File No: 110NTH09/01647  
Your reference 05\_0129  
Greg Sciffer

Department of Planning.. MP 05\_0129. Proposed Residential Subdivision.  
Lakes Estate. North Boambee Valley. Coffs Harbour.

11 SEP 2009

THE LAKES ESTATE
NORTH BOAMBEE, COFFS HARBOUR
PROPOSED SUBDIVISION

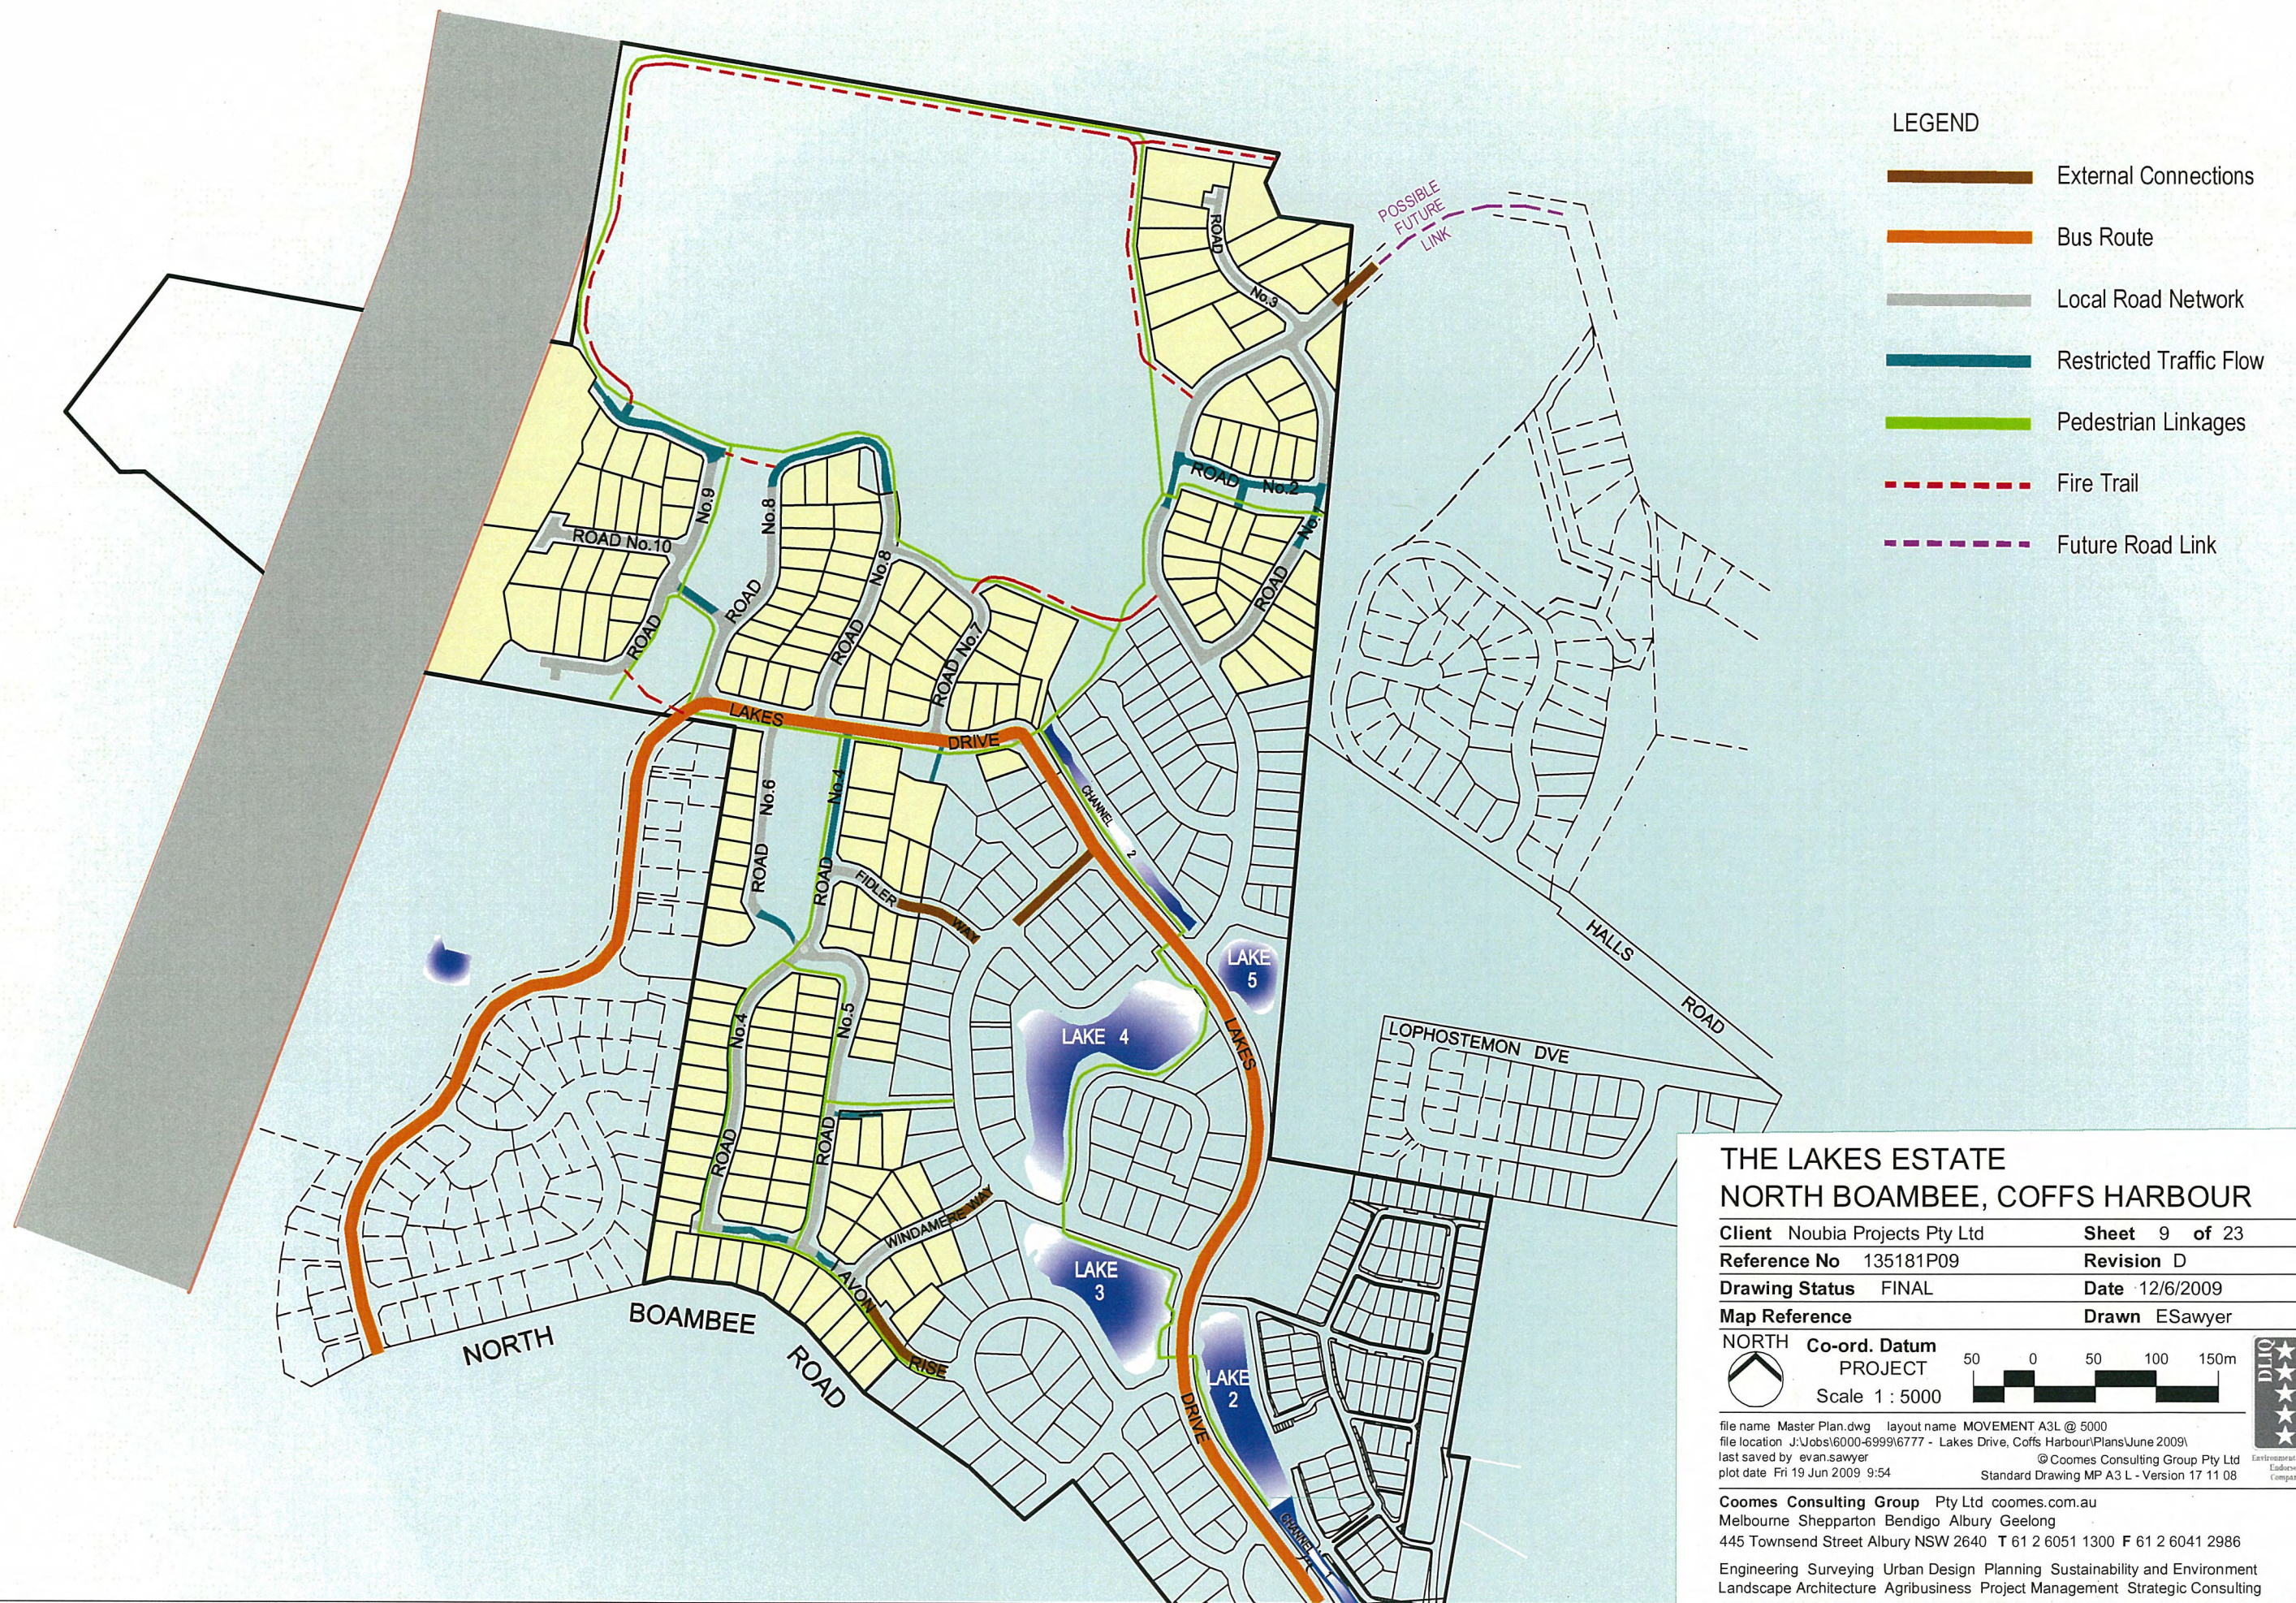
The proposed overall subdivision of 425 lots will have a significant impact on the existing and future road network in the area. At this time its only means of access is via North Boambee Road and the Pacific Highway.

The traffic report indicates that the previous traffic surveys (5,500vpd) in 2007 that North Boambee Road was almost at its capacity of 6,000vpd. The proposed subdivision will add an additional 4,250vpd to the local network.

Very little information has been provided regarding maintaining the safe and efficient operation of the existing and proposed local road network. The existing and proposed infrastructure needs to be assessed to make sure that it will have adequate capacity and that safe facilities are being provided for all road users including turning and through traffic. The RTA would recommend the use of AUSTRROADS guidelines to assess the appropriate treatments.

The subdivisional layout needs to be designed to provide for other modes of transport such as buses, bicycles and pedestrians. Infrastructure such as bus shelters, cycleways and shared pedestrian paths through the residential areas that connect to existing networks is required.
